**KIRKLEES METROPOLITAN COUNCIL
INVESTMENT & REGENERATION SERVICE**

Reference No:	2025/62/93183/E
Site Address:	41, Water Royd Crescent, Mirfield, WF14 9SY
Description:	Erection of two storey side extension
Recommending Officer:	Jennifer Booth

DECISION – REFUSED

Officer Report

Plan Reference Number: TQRQM25318173949762

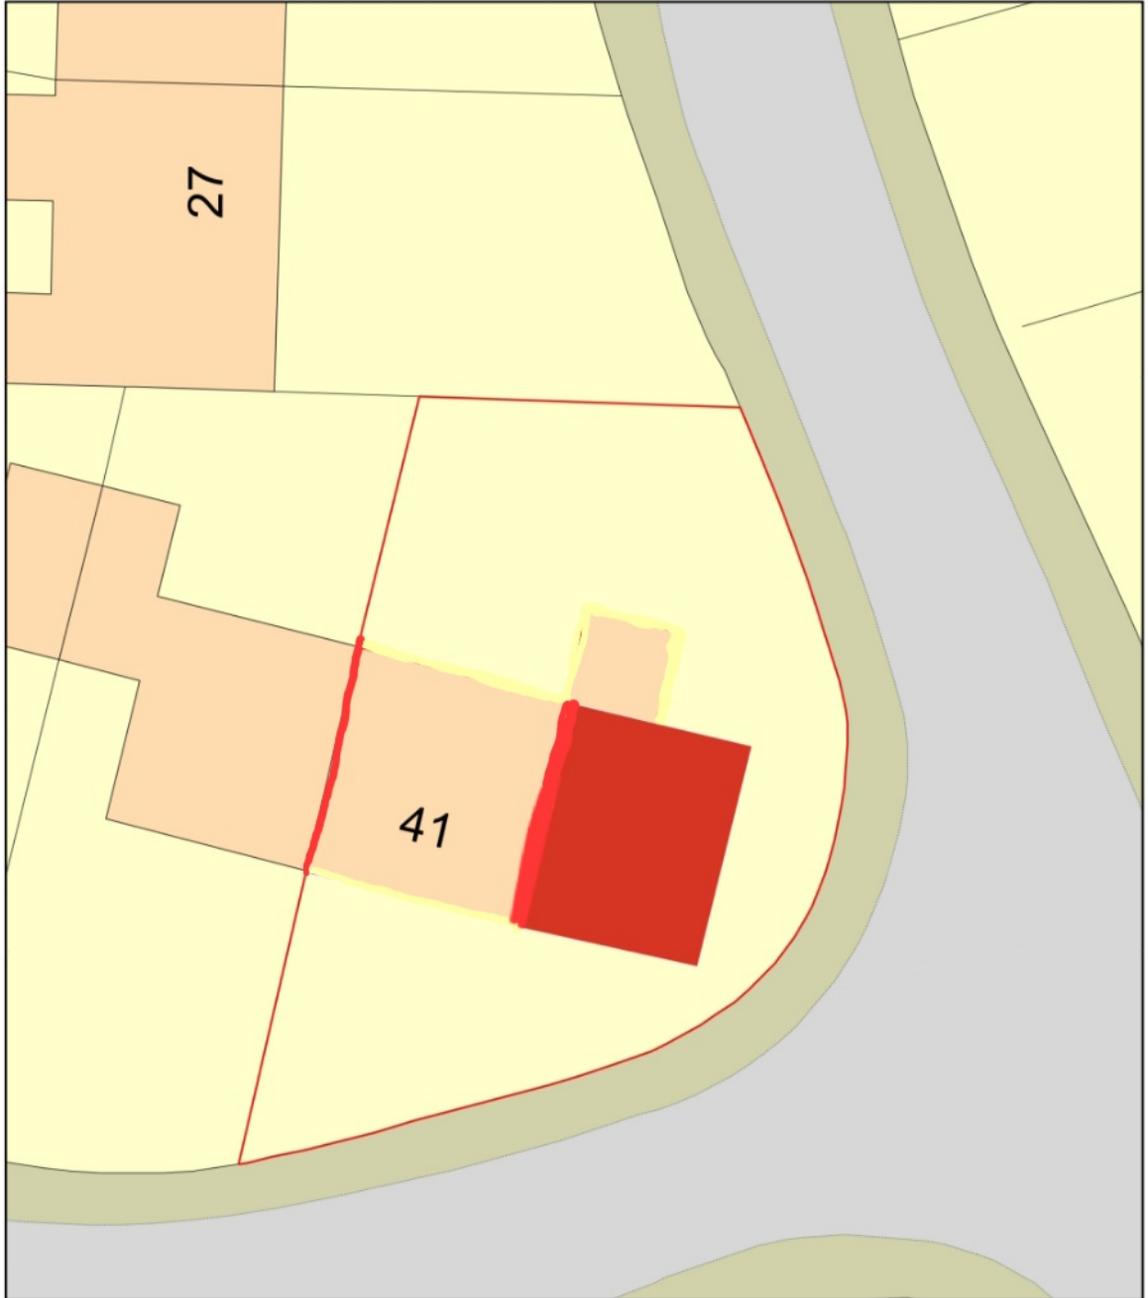
The SPD requires that two storey extensions should not take up all or most of the space to the side of a property. The submitted block plan (ref: TQRQM25318173949762) demonstrates that a gap of approximately 1.5 metres would be retained at the closest point from the boundary. There is a spaciousness within the street scene in this part of the street resulting from the area to the side which is open amenity space. The proposal would take up a large proportion of this area.

There would be a loss of amenity space as a result of the development, and this is demonstrated on the proposed block plan. It should be noted however that there appears to be adequate amenity space retained to the rear of the property. It is therefore considered that the loss of the amenity space to the side of the property would not be so harmful that it would for a reason for refusal and the proposal is concluded acceptable in this case, having regard to Principle 7 of the SPD in relation to outdoor space.

GROUND FLOOR PLAN

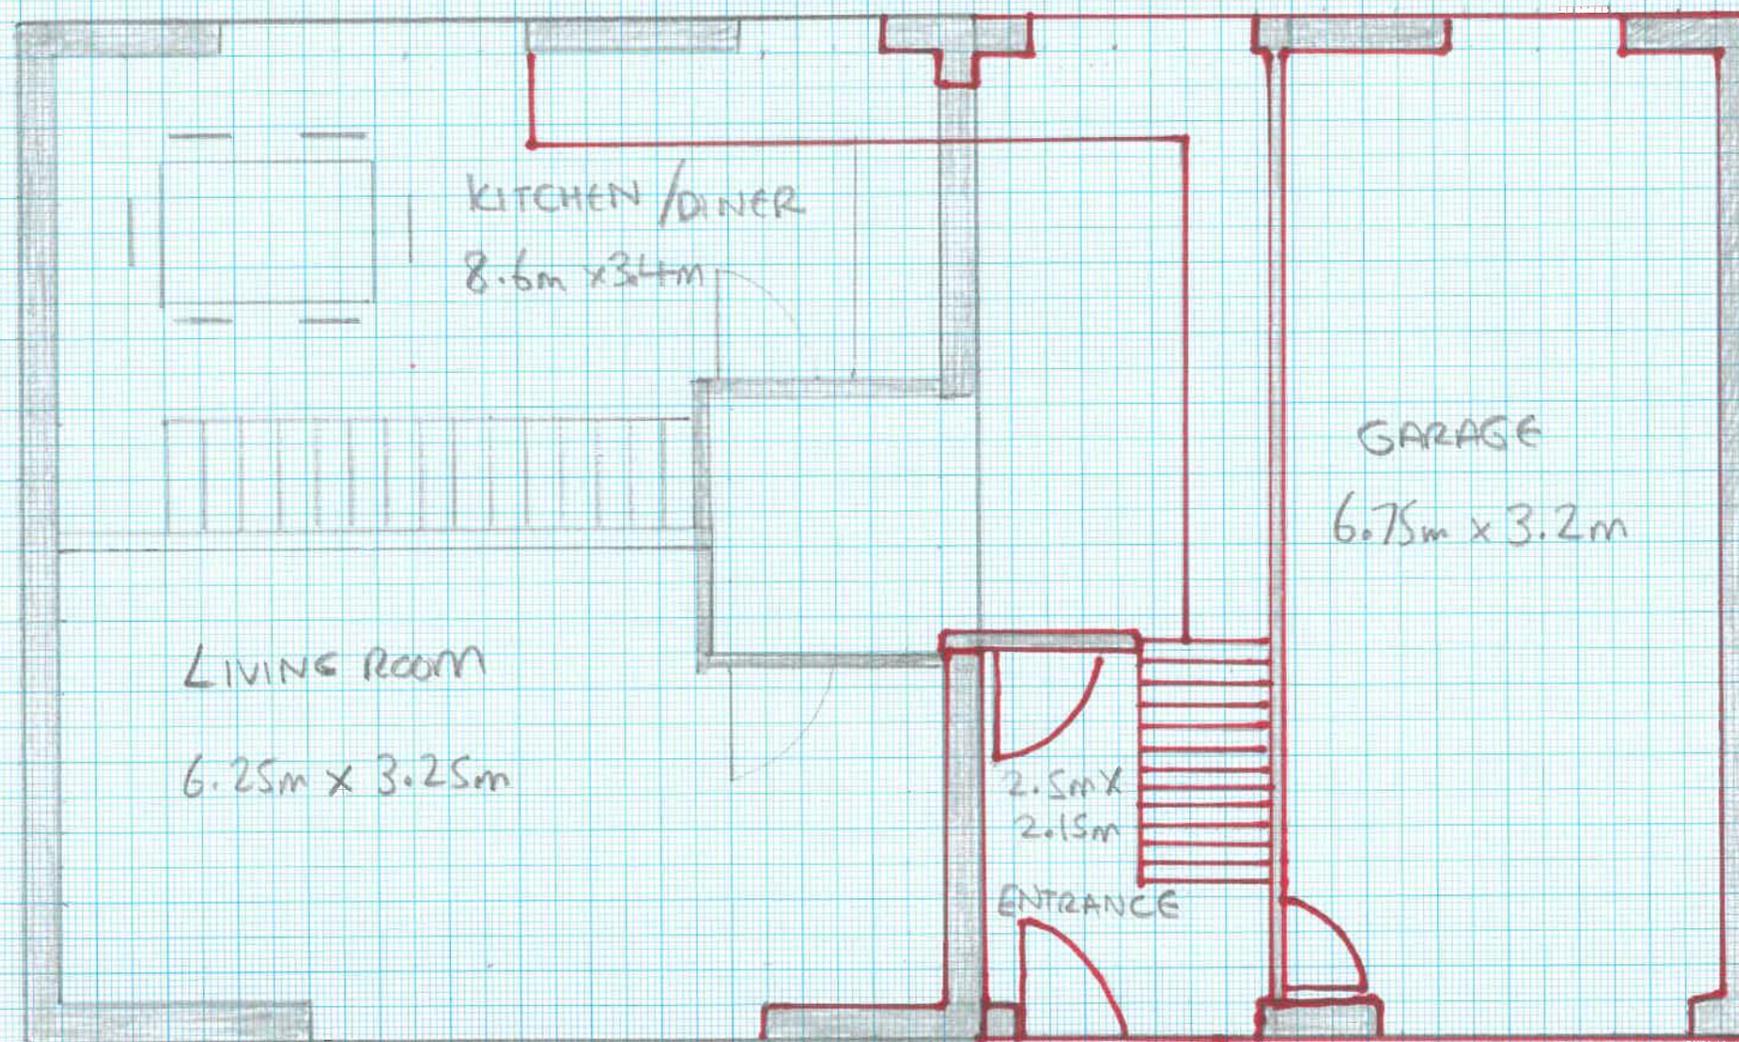
In this case the existing garage would be removed. However, the plans demonstrate that an integral garage would be created within the ground floor of the extension. In addition, the application form states that the small grassed area in front of the new garage will be tarmac to match the current driveway. The internal dimensions of the proposed garage indicate that a parking space can be achieved. The floor plans indicate that as a result of the extension, the property would have 4 no. bedrooms. The SPD states that properties with 4 + bedrooms require 3 off-street parking spaces.

In this case, 1 no. parking space can be provided within the garage area. The photographs from the site visit demonstrate that the area to the front of the property has been finished with tarmac and appears to be adequate to park 2 no. further vehicles.

SOUTH FACING
ELEVATION PLAN FRONT

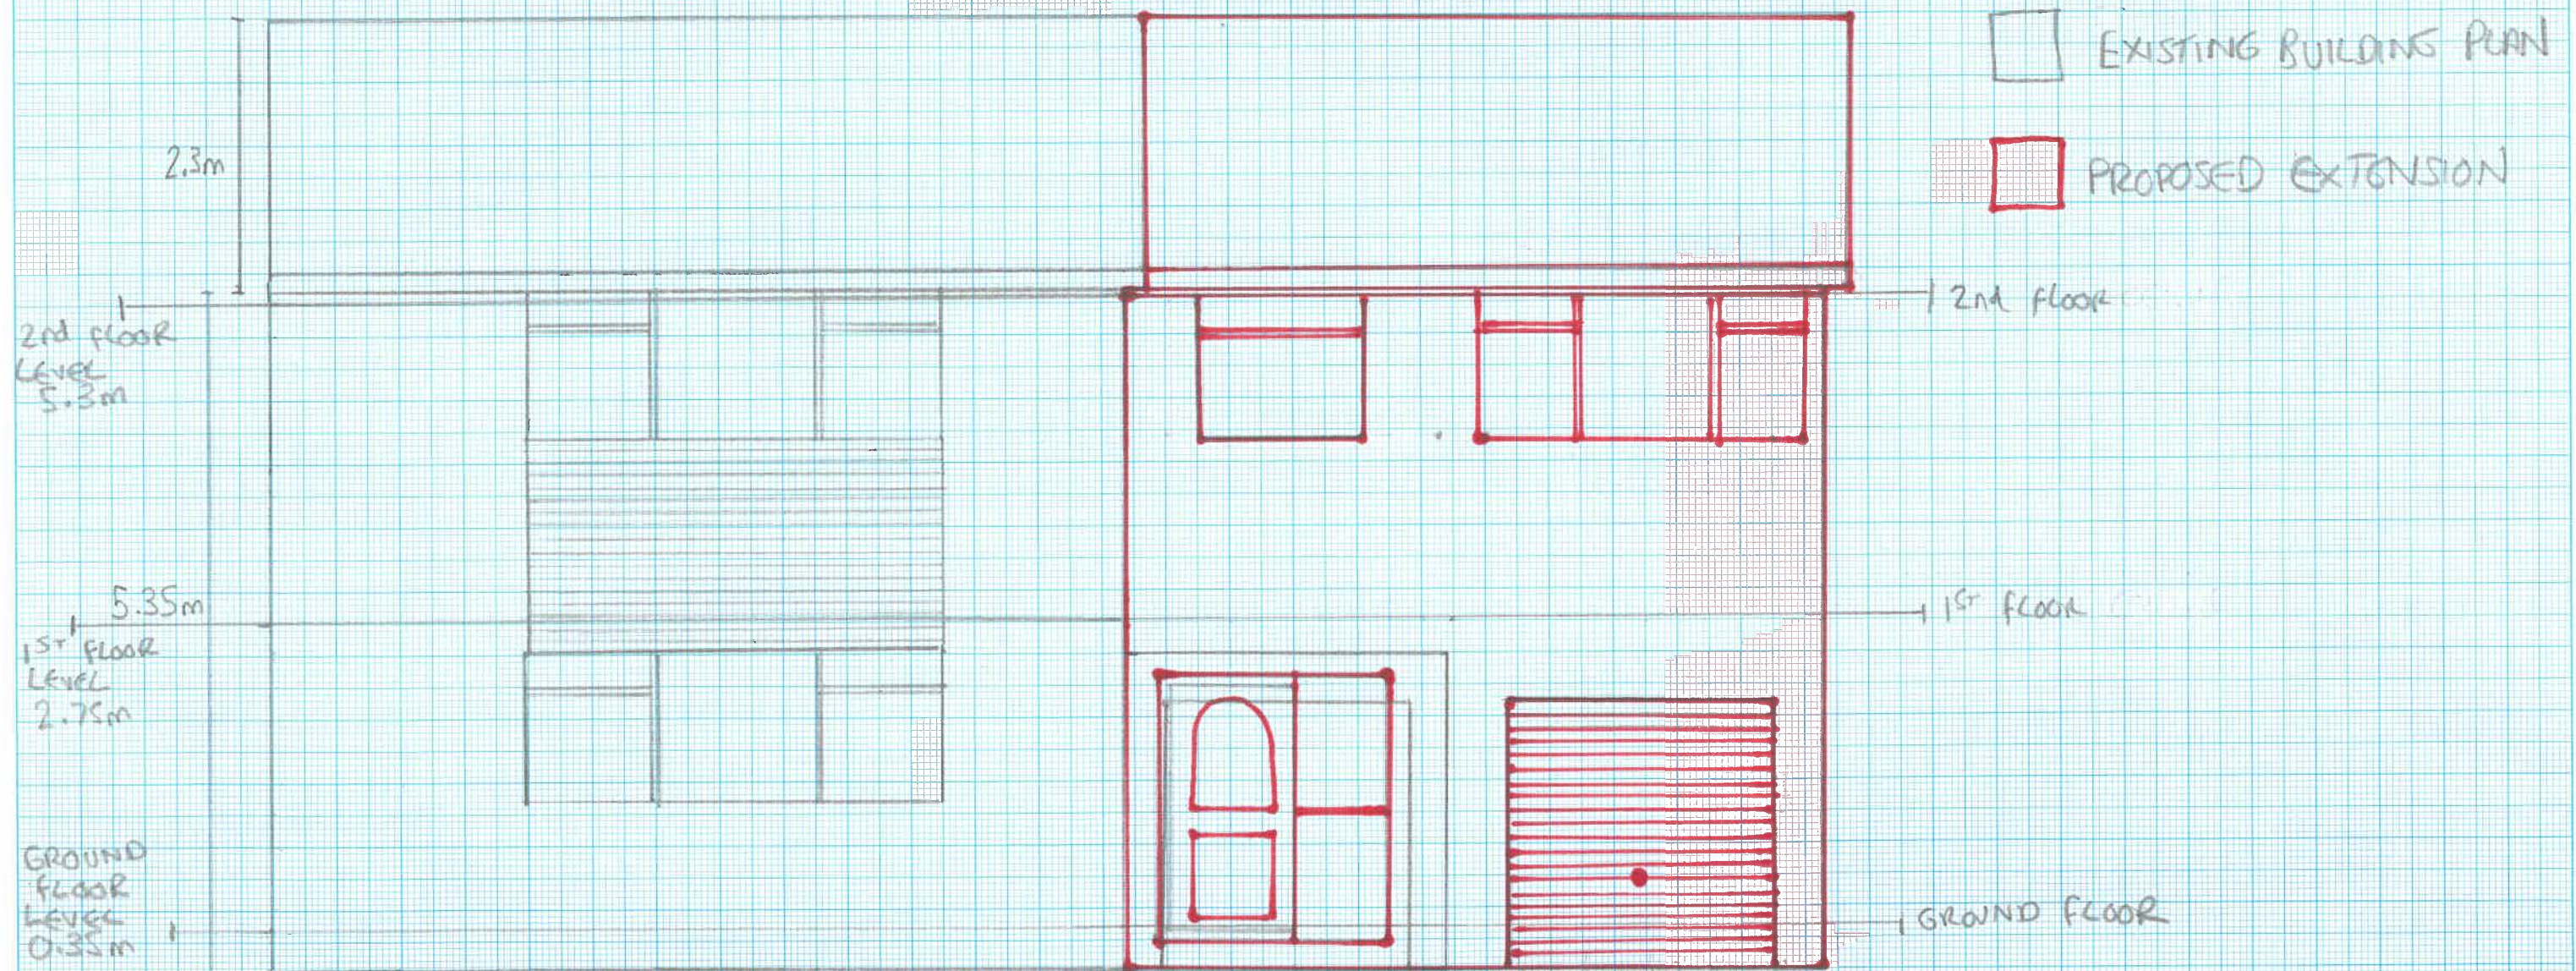
It is proposed that a two-storey extension would be located on the side elevation of the property. The design of the extension is such that the width of the extension would almost double the width of the property with the extension not being set down from the roof ridge or set back from the front elevation of the existing dwelling. Therefore, the works would not be viewed as subservient to the property as required by Policy LP24 of the Kirklees Local Plan and Principles 1 and 2 of the House Extensions and Alterations SPD.

The property is located within a corner plot and the SPD is clear in that extensions should be set in from established building lines and create a frontage. In this instance, the side elevation of the two storey extensions hosts no features of interests and would be a stark gable end in a prominent location which would not contribute to the street scene and does not have any openings that would create a frontage.

Alongside this, within sub-paragraph 5.23 the extension should be set back from the building line on both streets. Due to the design of the extension, this could not be achieved and would therefore be contrary to this section of the SPD. It is important to note that due to the existing layout of the property within the street scene, the building line to the north is already interrupted but would be exacerbated further by the presence of the extension.
